## SICEEP, South West Plot (SSD6011) – Response to City of Sydney Council

# SICEEP, South West Plot (SSD6011) – Response to City of Sydney Council

DEVELOPMENT APPLICATION
SOUTH WEST PLOT
WEST ELEVATION

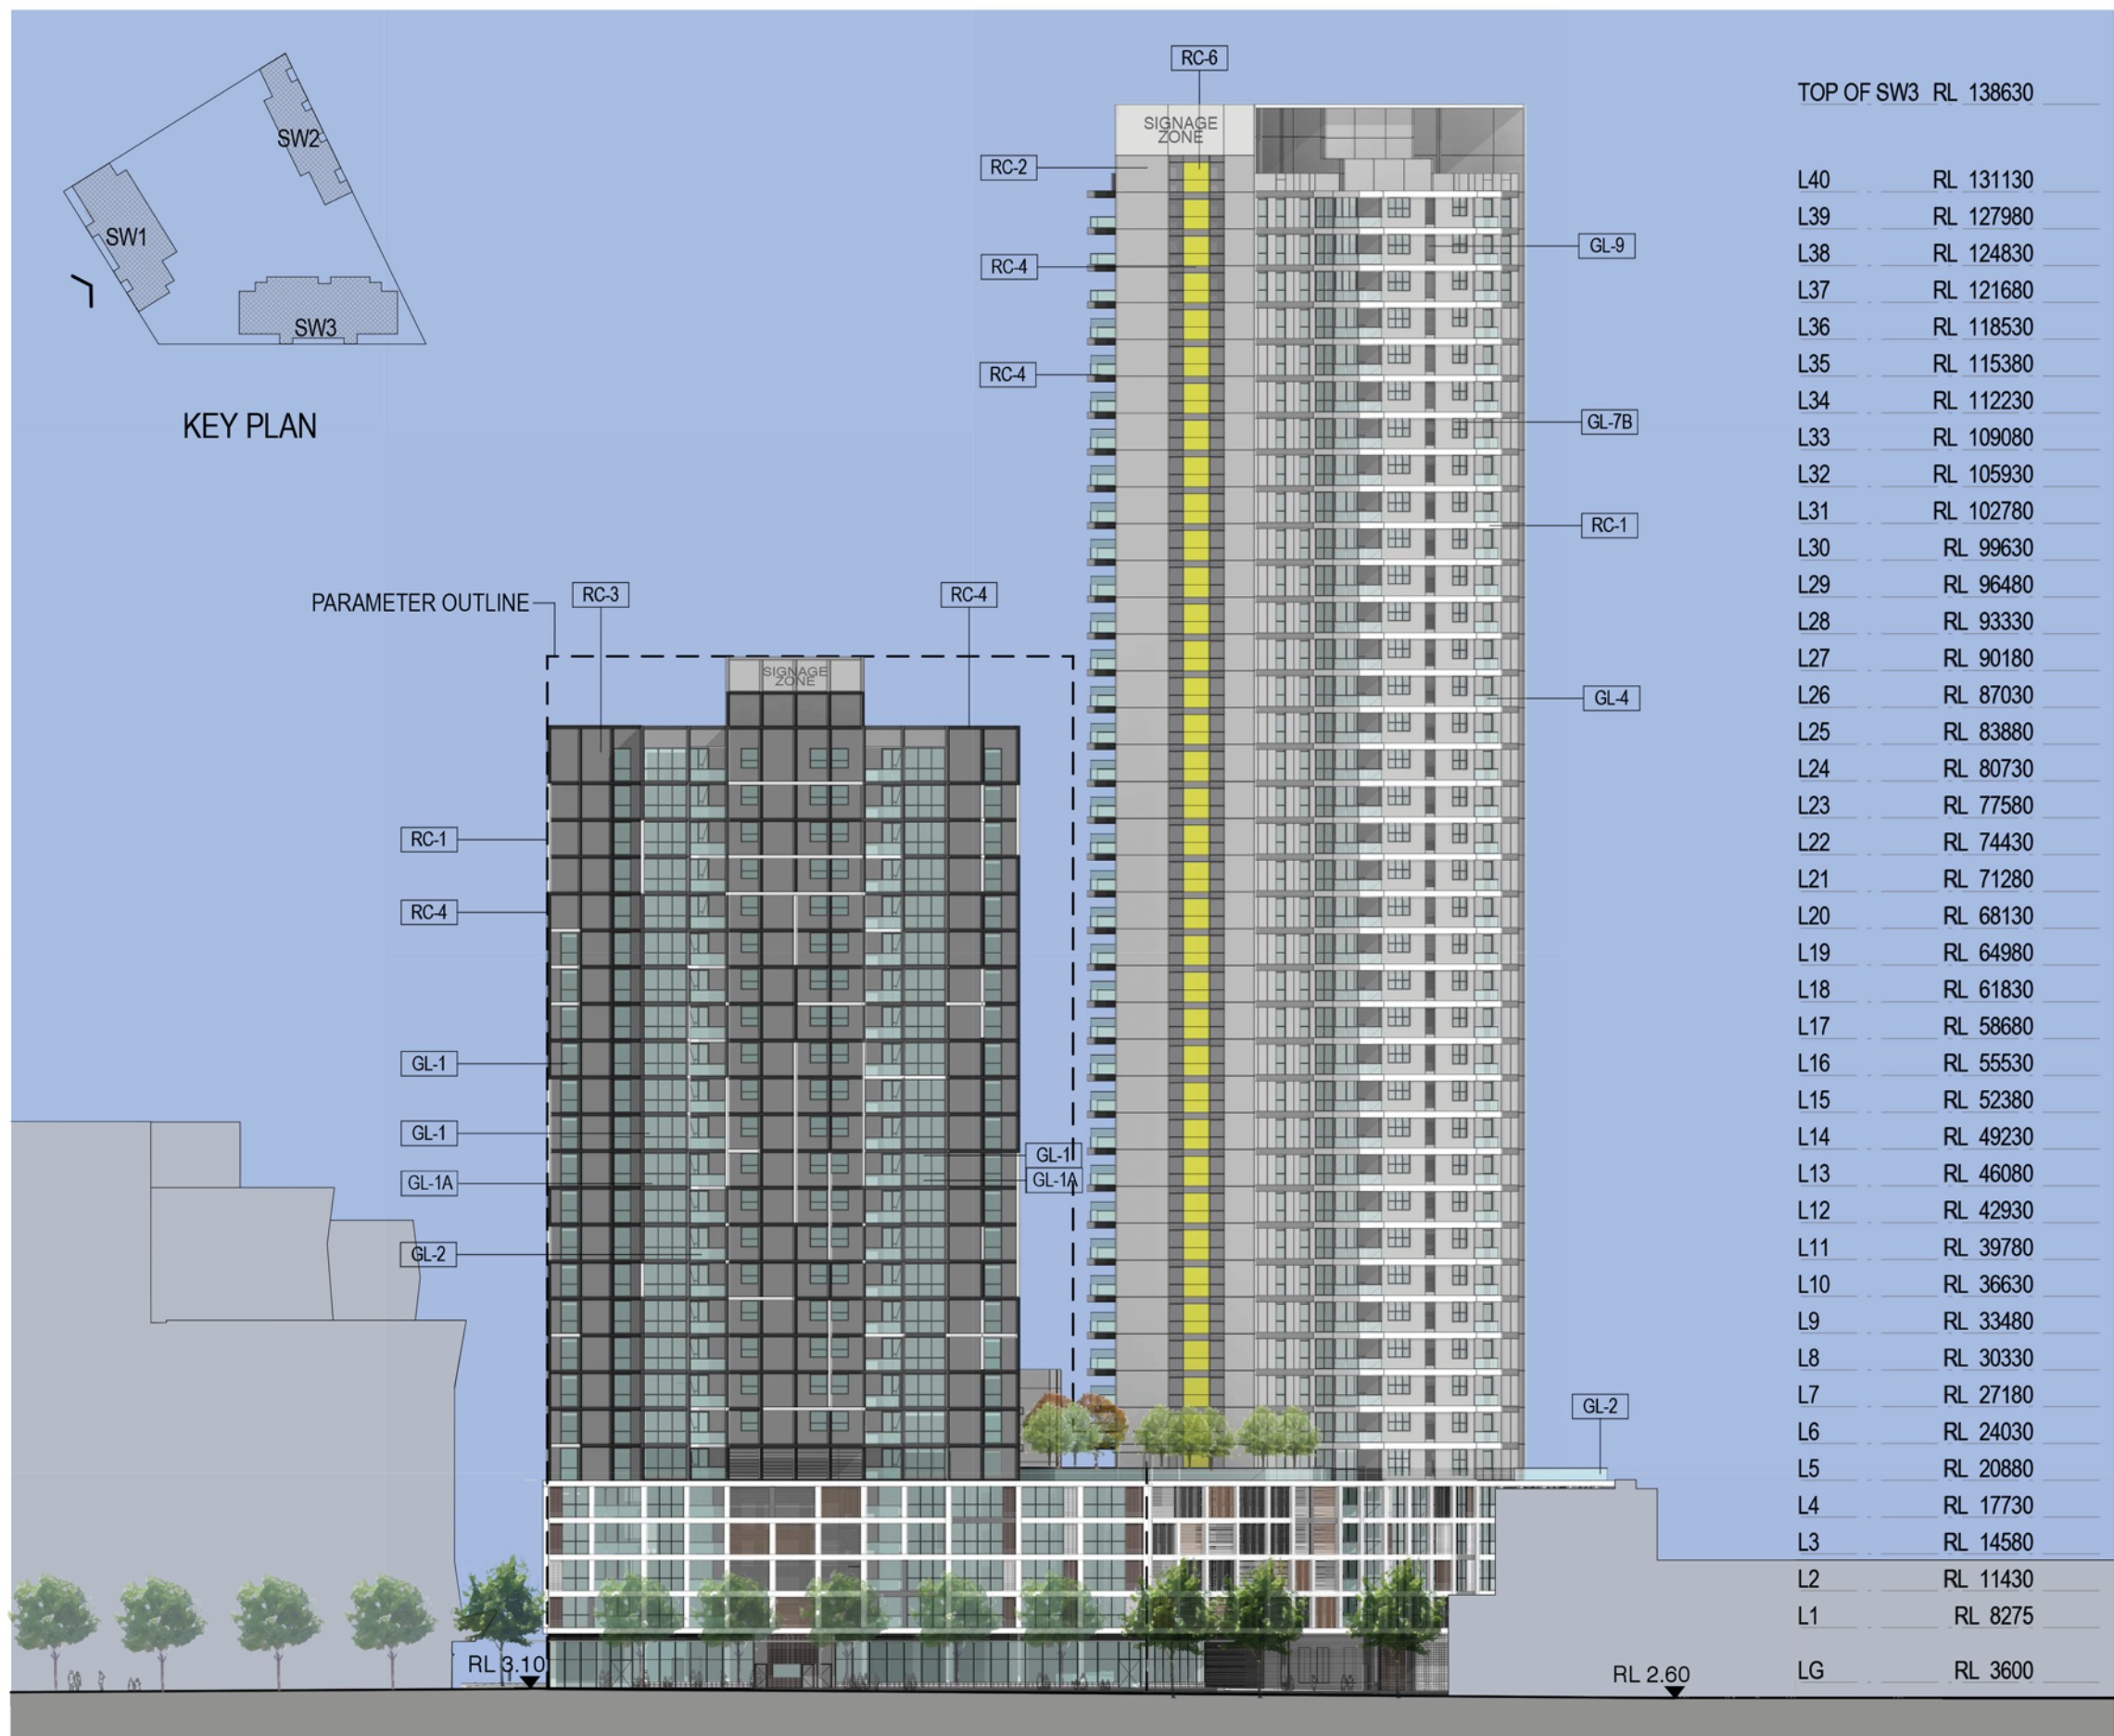
c) SW1 Overhang

*The Department considers that the cantilevered projecting bay should be removed and notes Council's concern in this regard*

Please refer to Key Issue 2 and B2 as outlined within the Response to Submissions which provide adequate justification for the projecting bay.

As noted within the Design Report submitted for SSDA5 the provision of an apartment bay on the western face of SW1 tower has positive urban design/architectural benefits:

- The apartment bay provides a more visually interesting elevation when viewed along Macarthur Street by replacing a blank core facade with residential apartments;

- The projecting bay provides a more 3 dimensional expression of the SW1 tower built form, breaking up the previously flat western elevation;
- The projecting bay lies on the Macarthur Street axis recognising the visual terminus of this street axis;

- By projecting the apartment by 2.4 metres – the equivalent of a balcony zone – instead of setting the tower back flush the minimum separation between towers SW1 and SW3 is maintained;

- The projecting bay does not reduce the minimum visual separation between buildings along Darling Drive set within the parameter plans.
- Located on the western elevation, the projecting bay does not impact view lines from any tall buildings as per the view impact analysis; and

- The projecting bay sits wholly within the approved parameter envelope that provides for a bay of this nature.
- The projecting bay has been designed so that it does not have an overbearing presence on Darling Drive.

- The human scale of the podium responds to the streetscape and pedestrian experience whilst the projecting bay is read as part of the tower in the skyline and in particular addresses the Macarthur St terminus.
